Rezoning Transportation Analysis

Petition Number: Insert Zoning Petition #2021-260

Date	Description
04-18-2022	First Review (WB)
05-25-2022	Second Review (WB)
06-29-2022	Third Review (WB)

DATE: 11/03/2021  
DESIGNED BY: CMG  
DRAWN BY: JYK  
CHECKED BY: JYK  
SCALE: 1/8" = 1'-0"  
PROJECT #: 1021386  
SHEET #: **RZ-1**

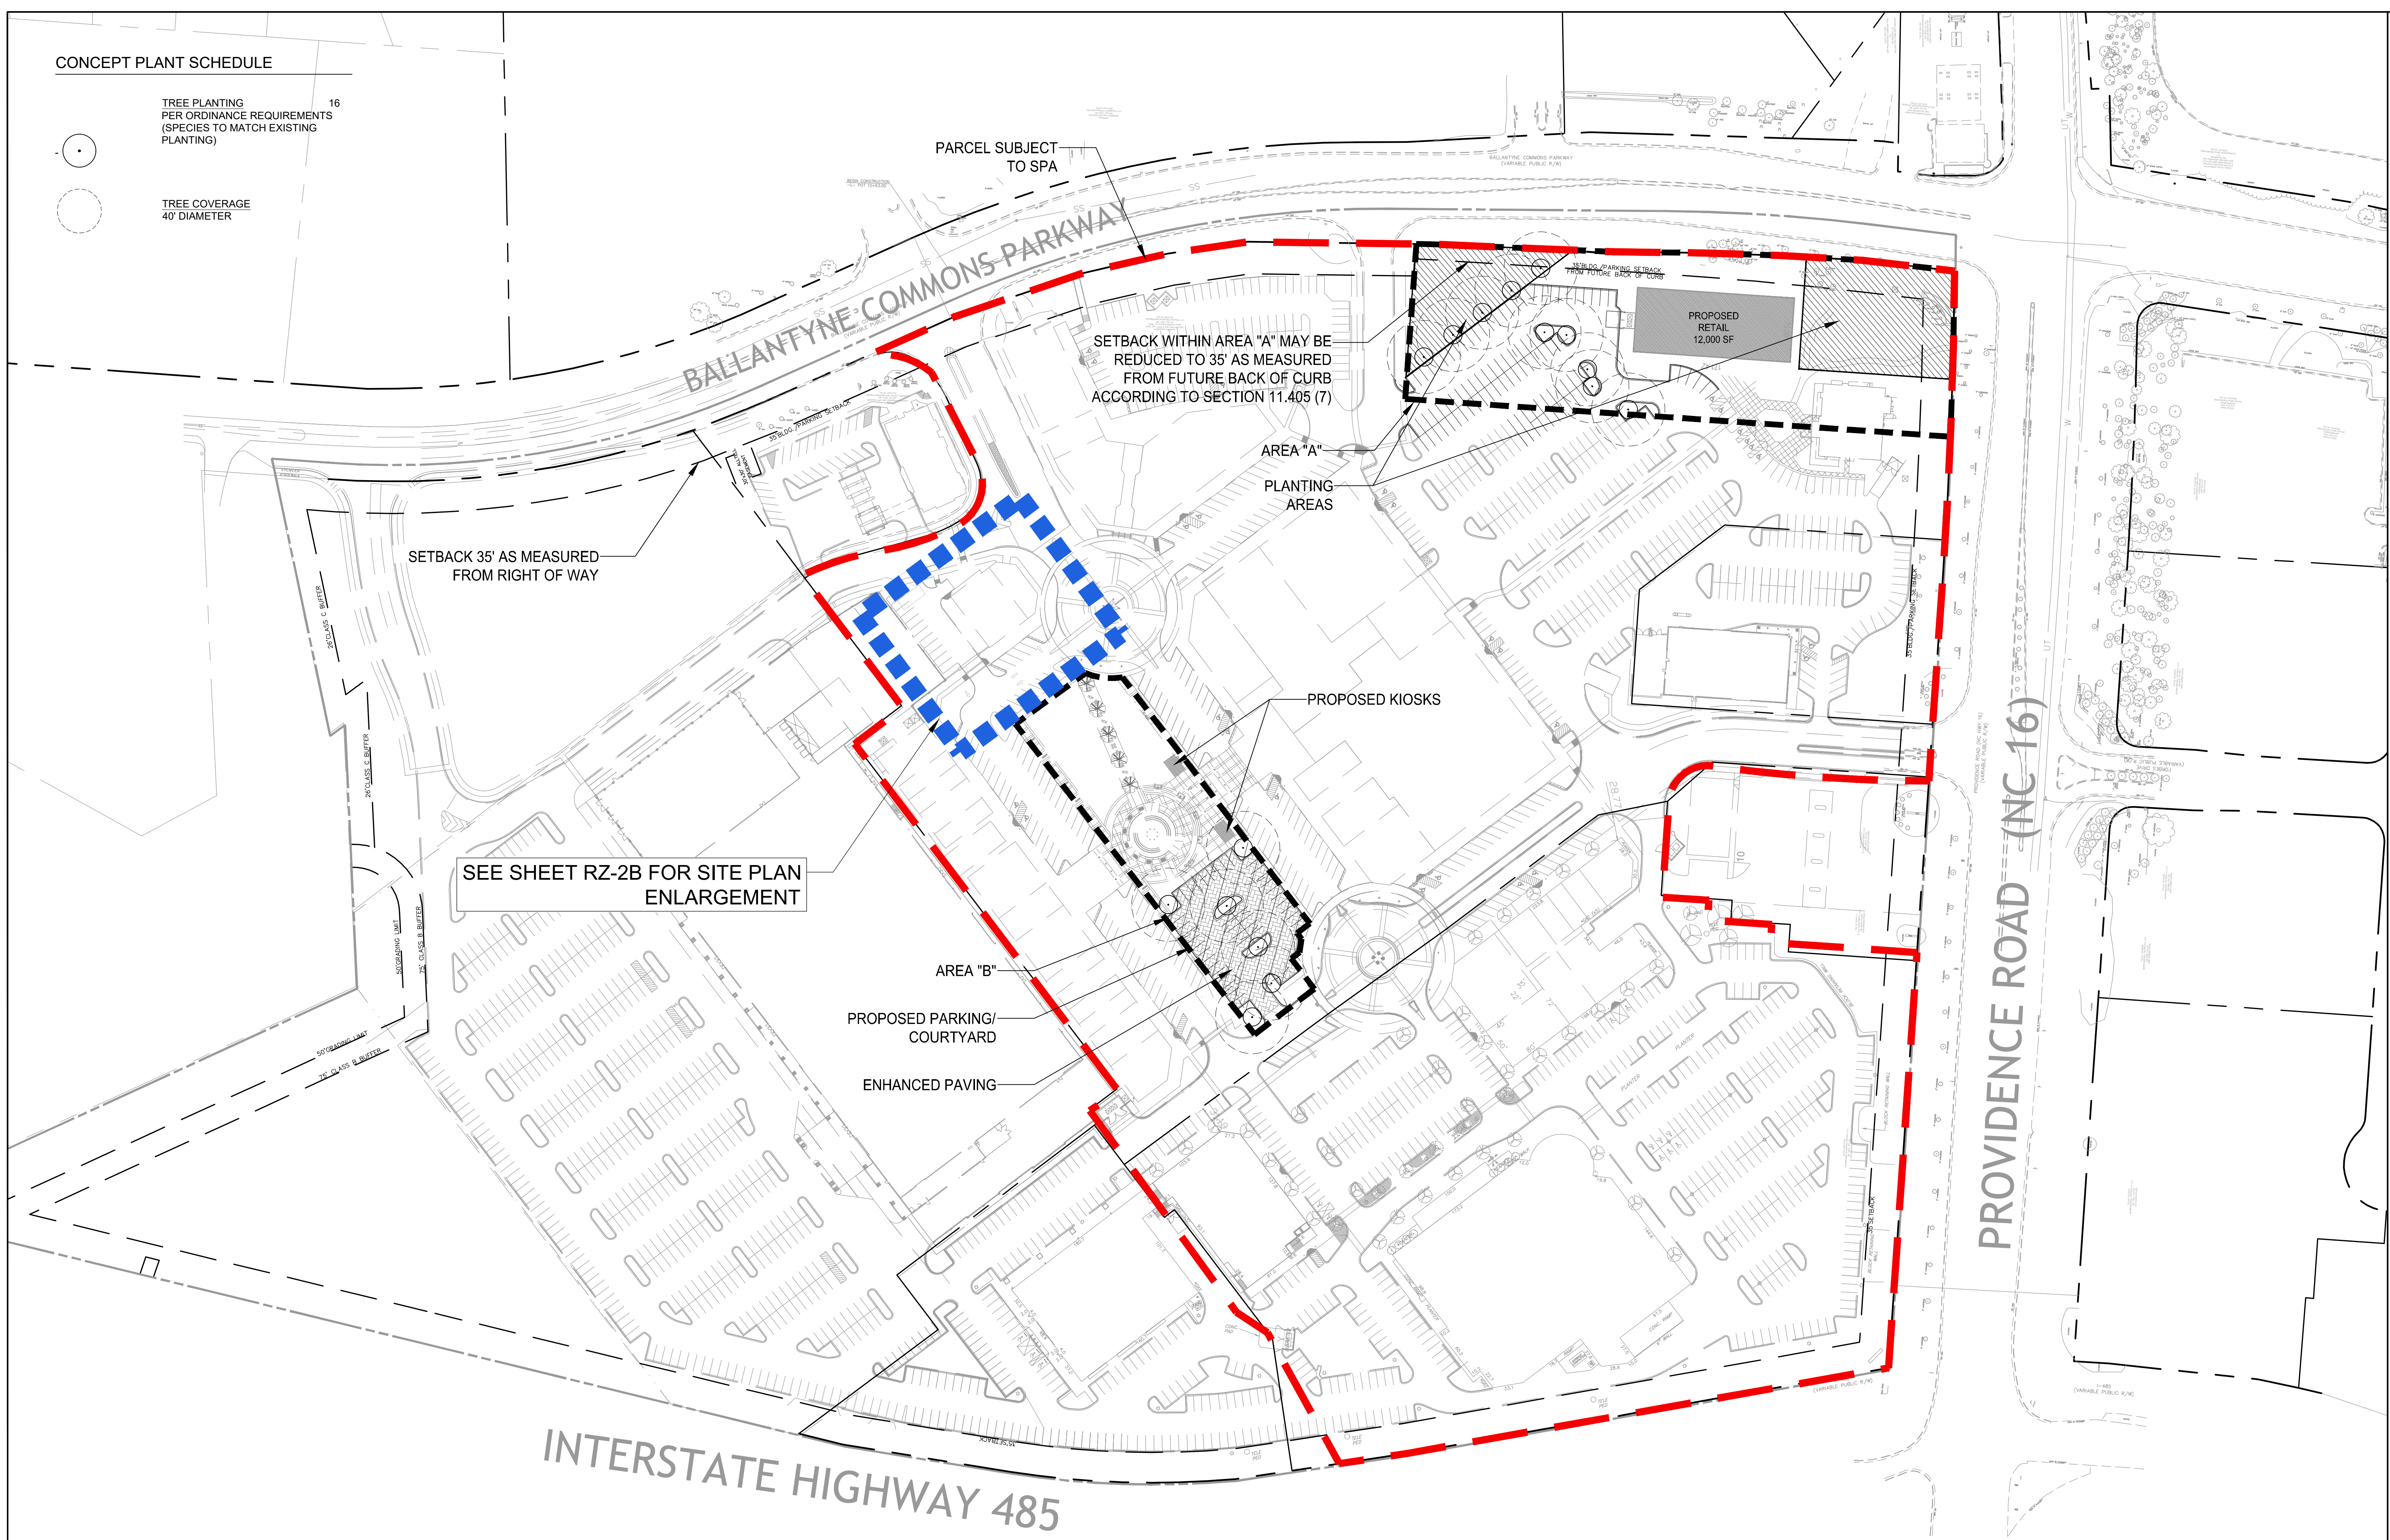
1. ~~**Curbline:** The proposed zoning district has a setback measured from back of the existing or proposed future curbline.~~
 - a. ~~**Ballantyne Commons Parkway:** The existing curb and gutter is in its future location.~~
 - b. ~~**Providence Road:** The existing curb and gutter is in its future location.~~

~~Label and dimension the curb and gutter from the centerline for each road on the site plan.~~

**RZ-2B**

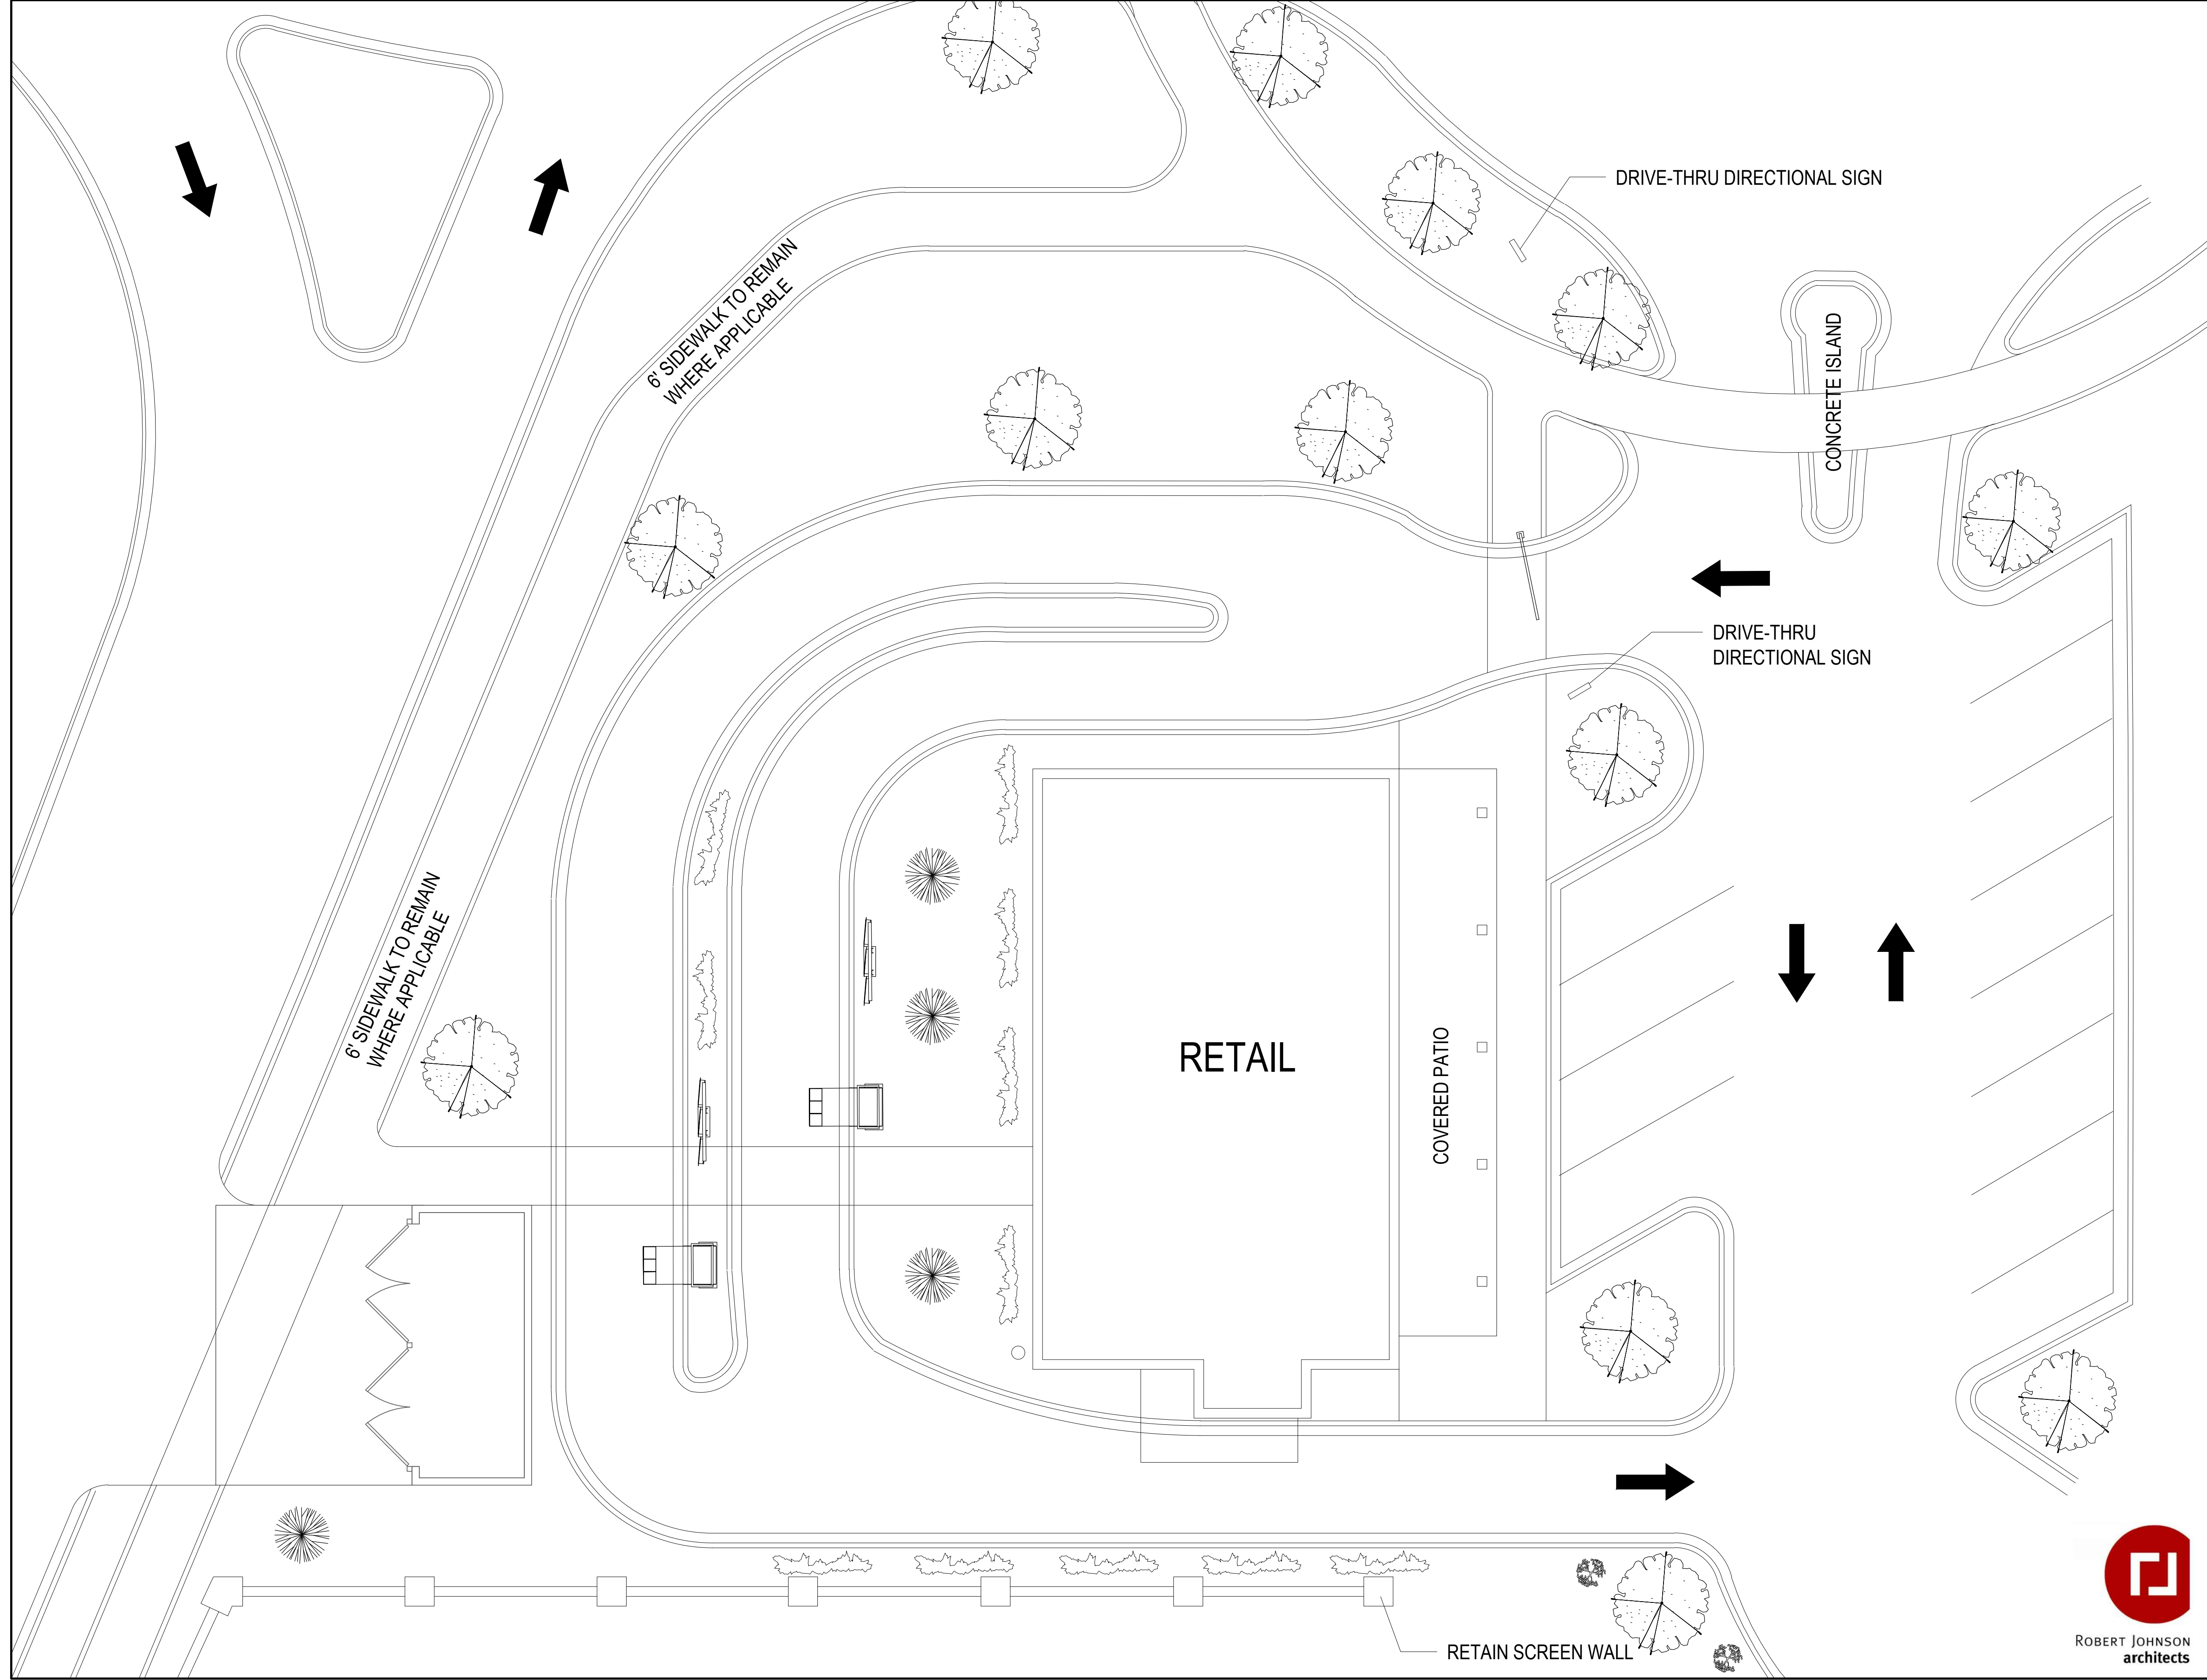
- ~~3. Revise site plan and conditional notes to provide on-site stacking without queueing within the roundabout or the Promenade Drive stem toward Ballantyne Commons Parkway.~~

The site is located at the southwest quadrant of two State maintained Major thoroughfares, Ballantyne Commons Parkway and Providence Road. A Traffic Technical Memorandum (TTM) was required due to access and queuing concerns. The TTM concluded that the proposed on-site staking for 22 vehicles will be adequate. The TTM was reviewed and approved by CDOT on June 15, 2022. CDOT has no outstanding comments.
